The Planning Inspectorate

Our ref: RA/2023/145638/01

Application by National Grid Electricity Transmission (NGET) for an Order granting Development Consent for the Yorkshire Green Energy Enablement (GREEN) project: Written Representation.

NATIONAL GRID (YORKSHIRE GREEN ENERGY ENABLEMENT PROJECT) ORDER  
 STATUTORY OR NON-STATUTORY SITES OR FEATURES OF NATURE CONSERVATION KEY PLAN  
 REGULATION 5(2)(I)(i)  
 SECTION E, SHEET 1 OF 1

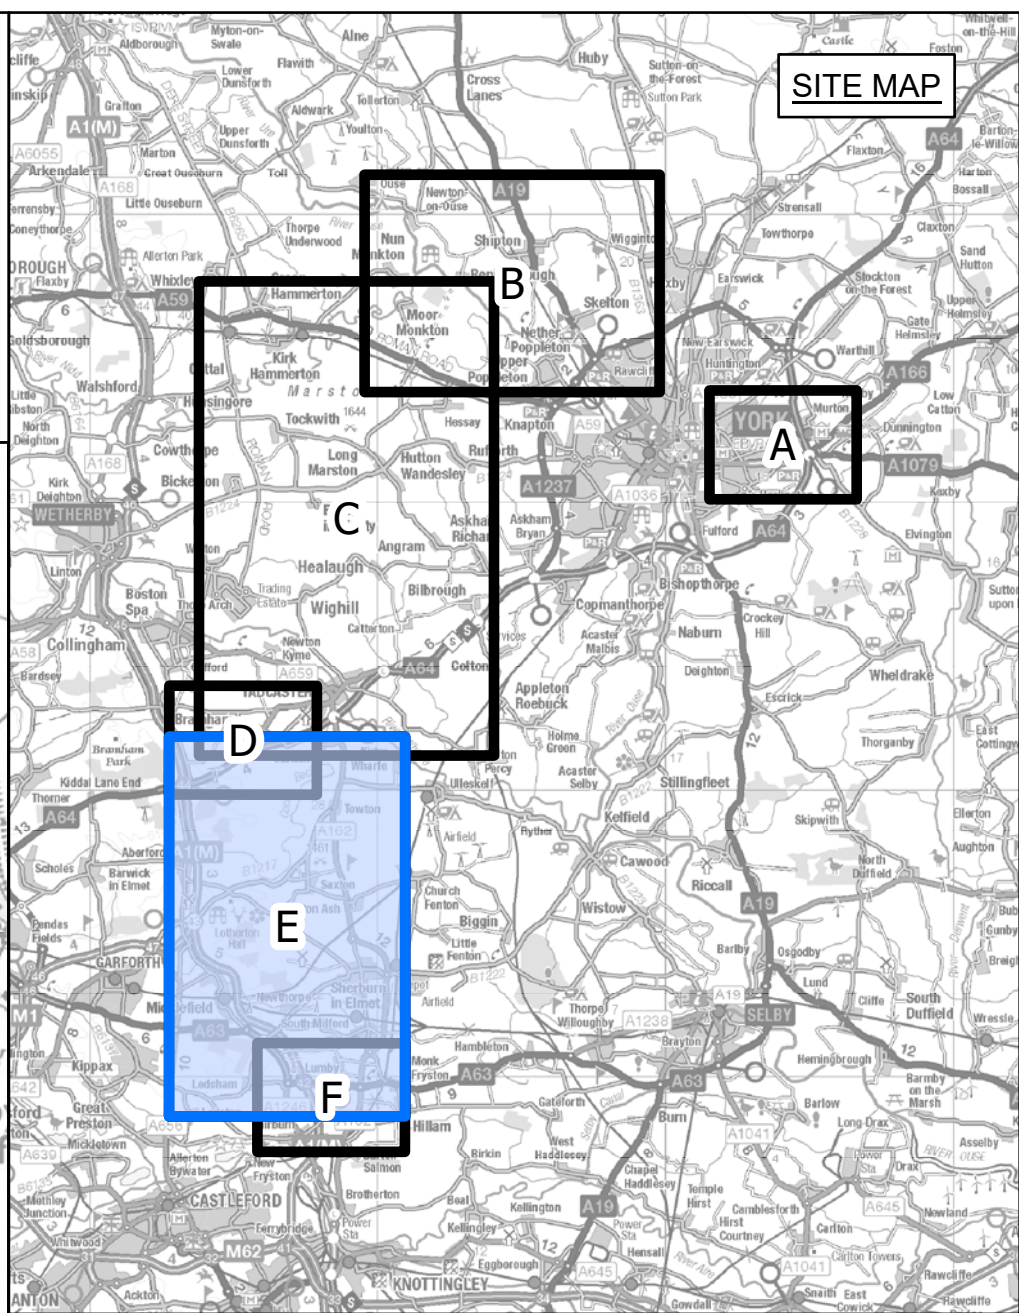
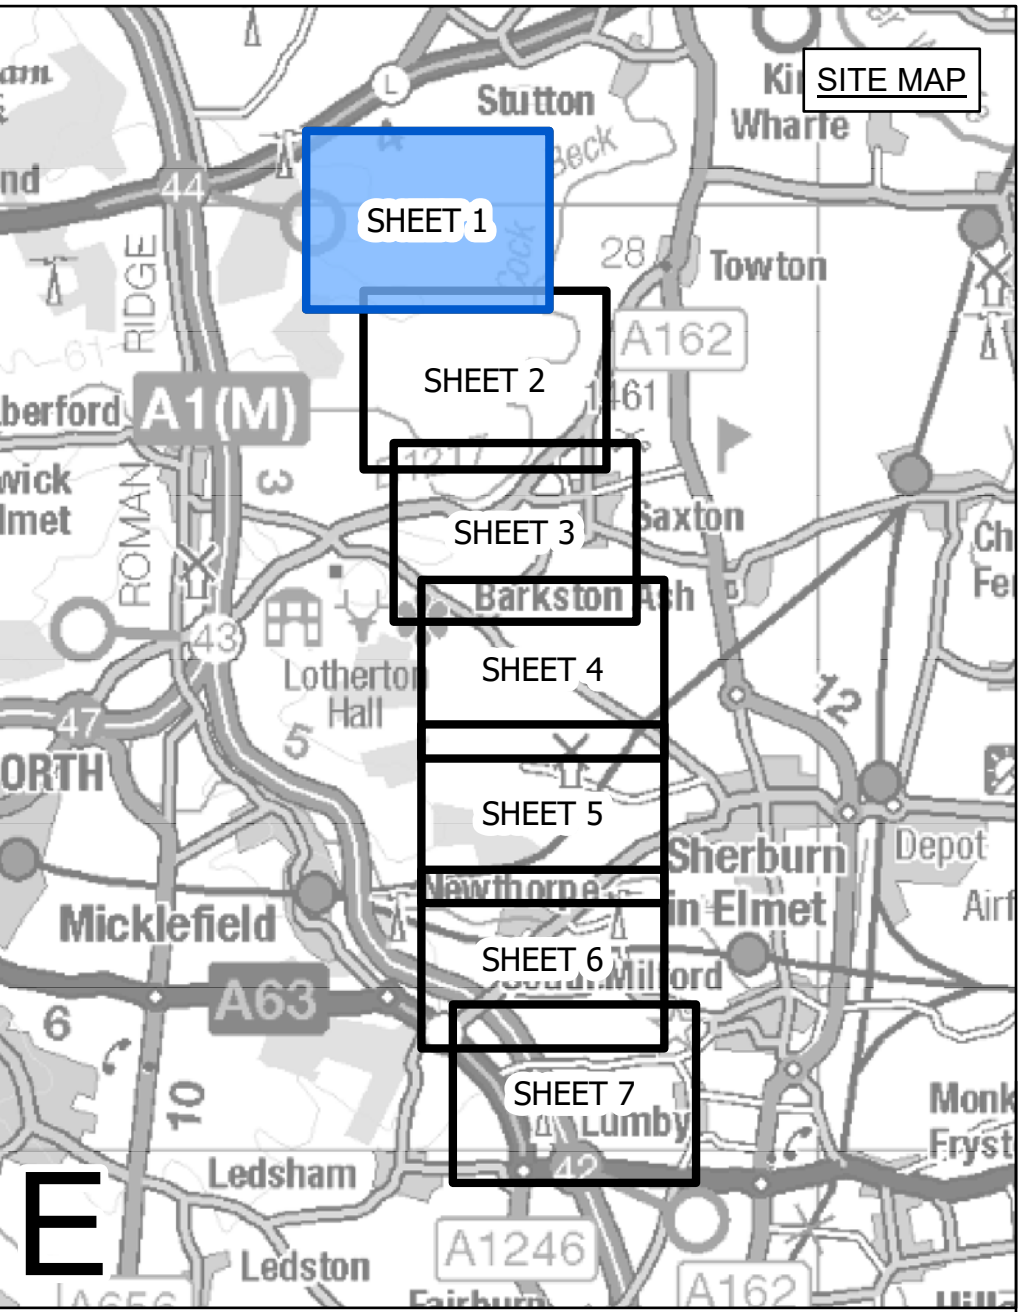
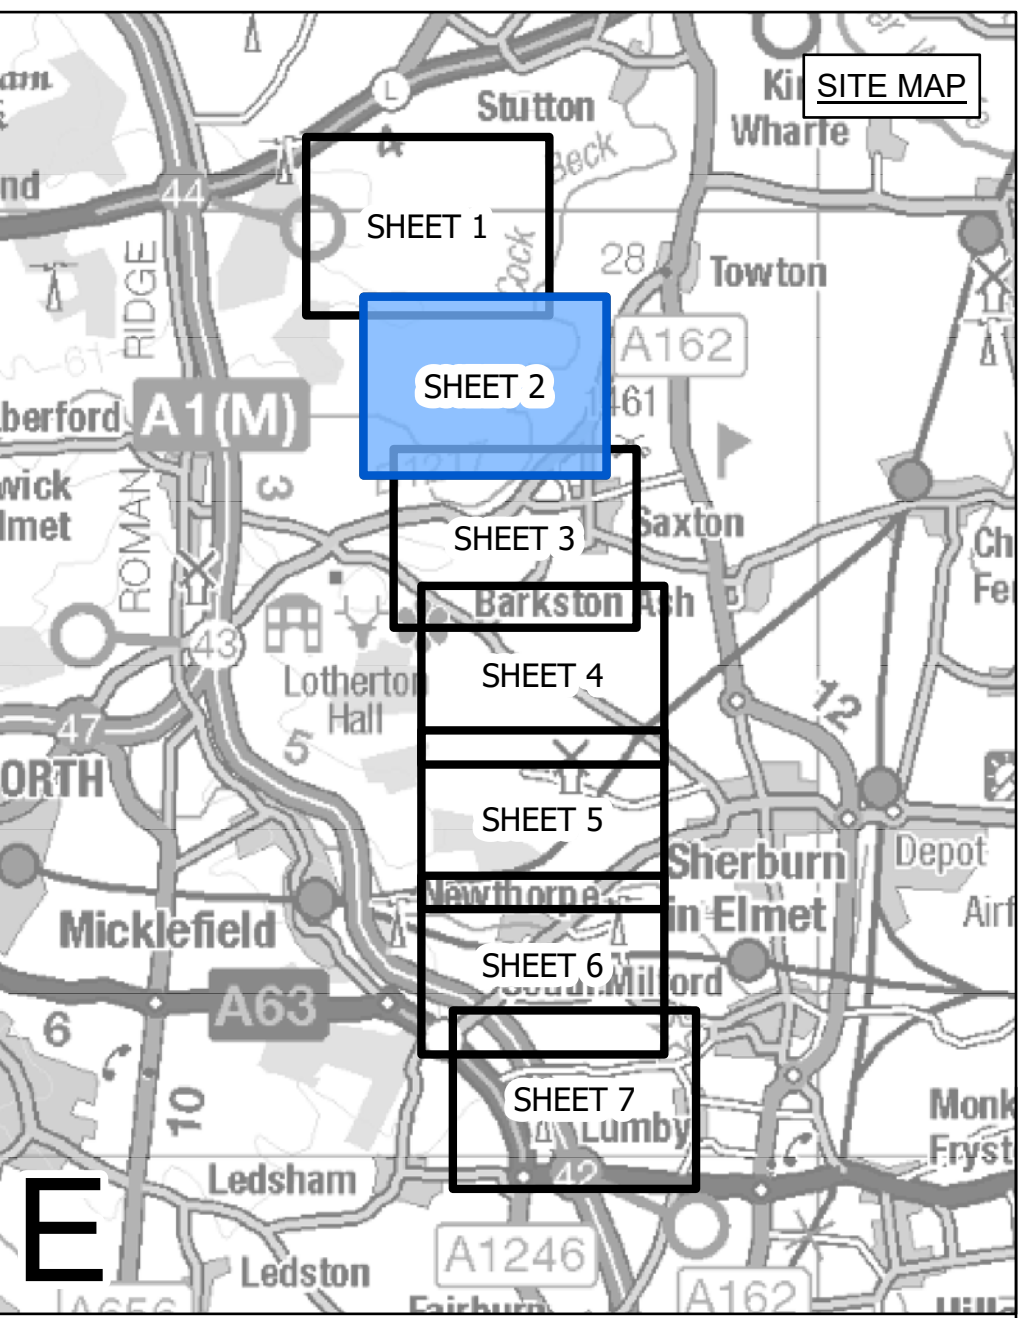
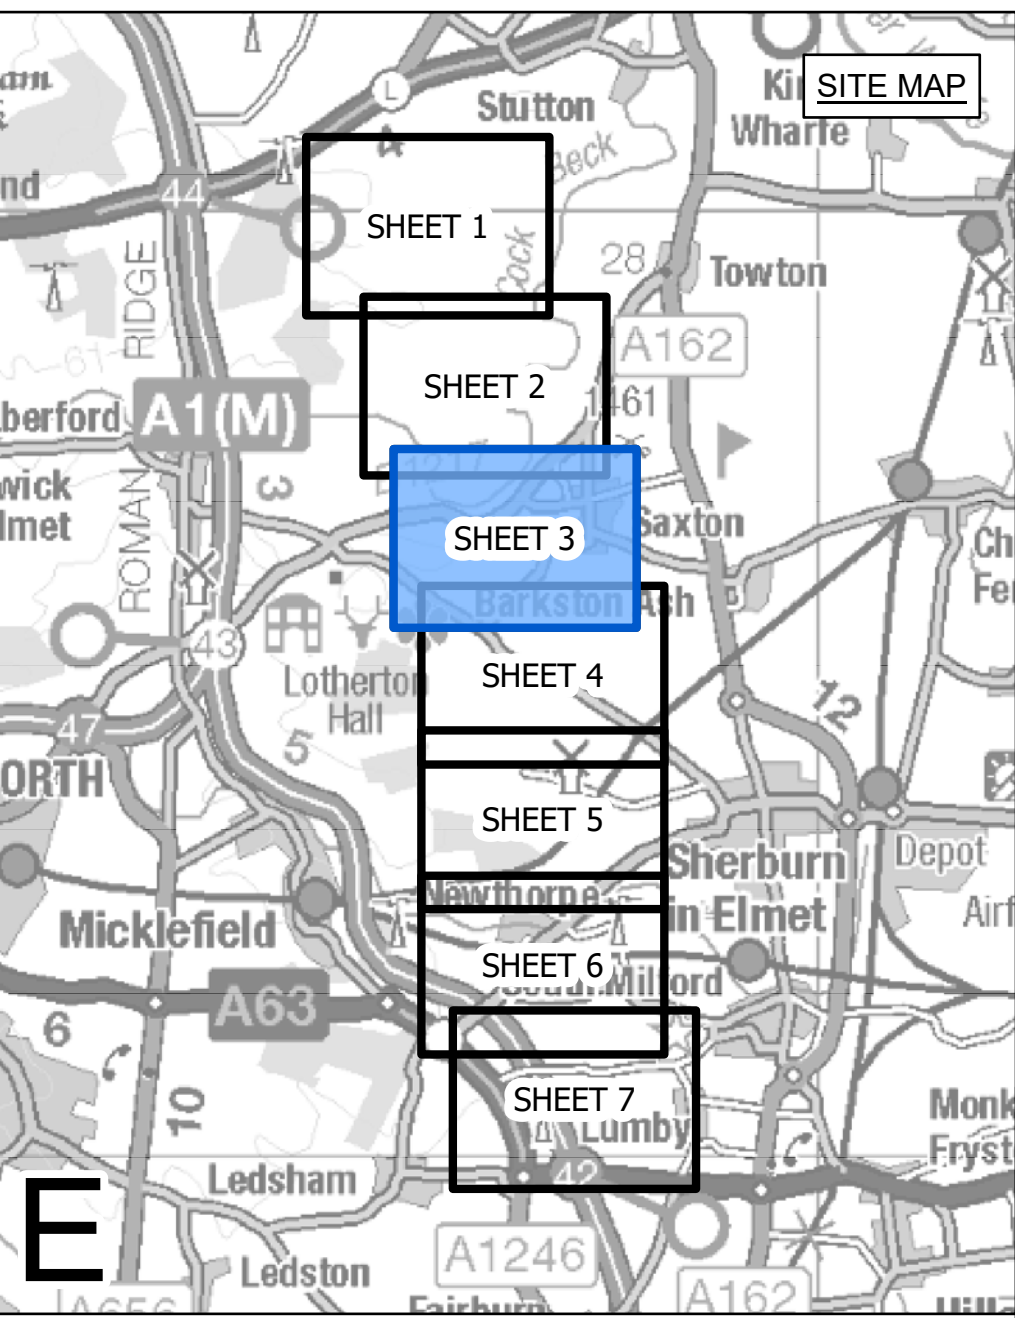
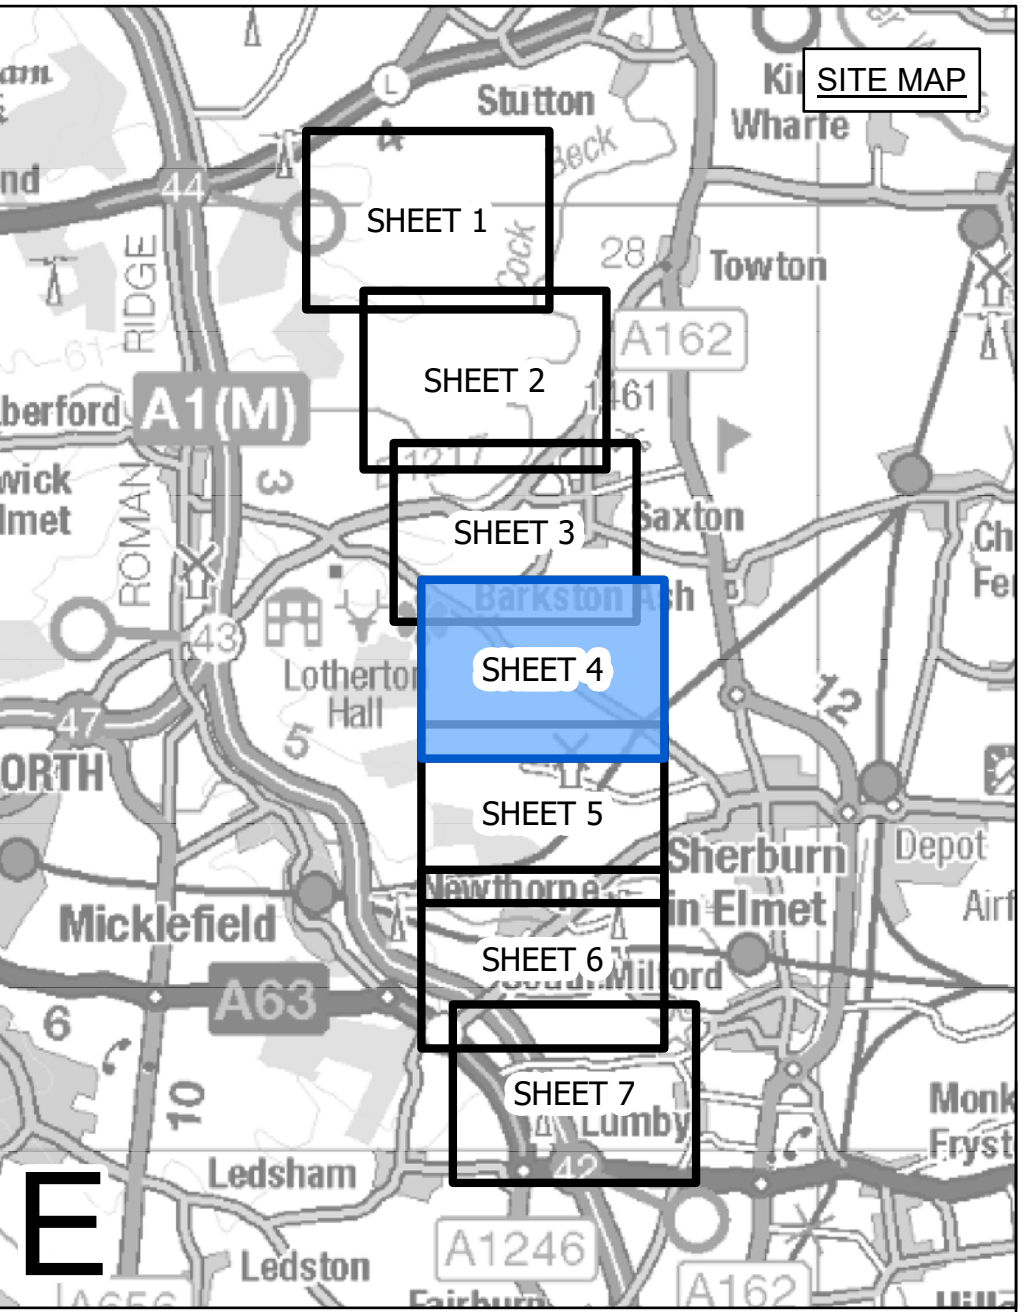
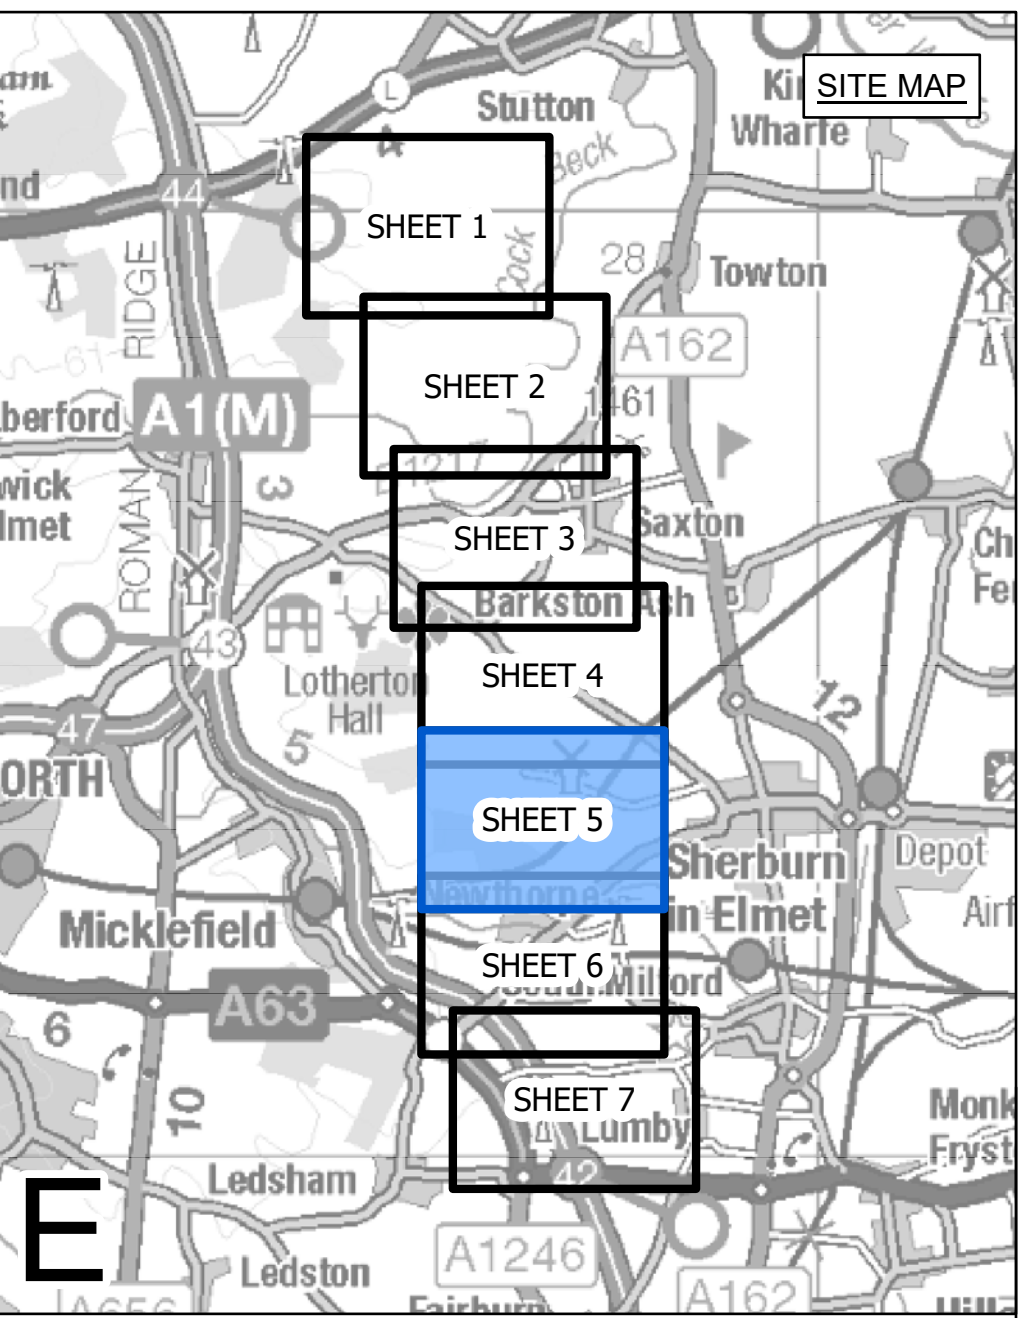
APP-036, very near eastern edge of Huddleston Old Wood, opportunities for implementing Biodiversity Net Gain (BNG)?
